From: Clare Dales
Sent: 27 March 2018 11:48
To: Anita Gardner
Subject: FW: Planning Consultation on: AB/18/18/PL

**ADC Planning Consultation
Conservation/Design Officer Response**

Application Number	AB/18/18/PL
Address	Norfolk Arms Hotel 22 High Street Arundel BN18 9AB
Description	Proposed new internal doors to third floor & proposed internal finishes to ground floor 'Town Bar' This application affects the character and appearance of Arundel Conservation Area
Case Officer	Mrs A Gardner
Date	27 TH March 2018

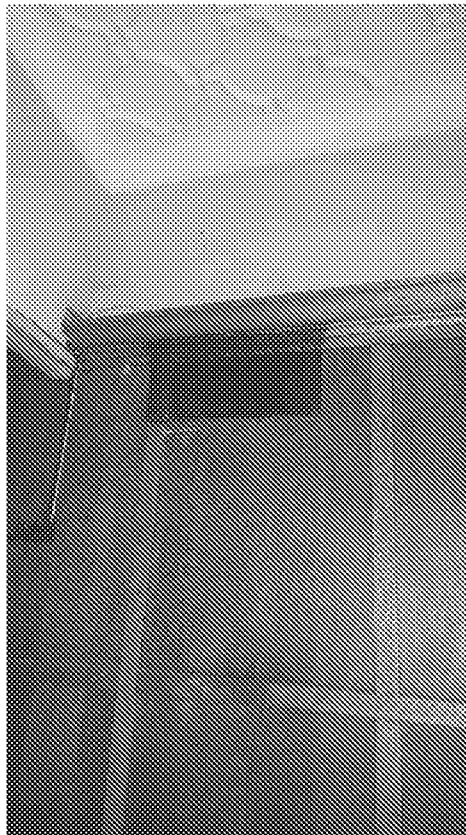
The applicant wishes to improve the appearance of the stone fire surround, also believed to be non-historic and part of the 1970's cosmetic works. It is desired by the applicant that the stonework is made good via application of lime plaster, to which the desired metro tiles in Victorian Green can be applied. This item is recommended for approval.
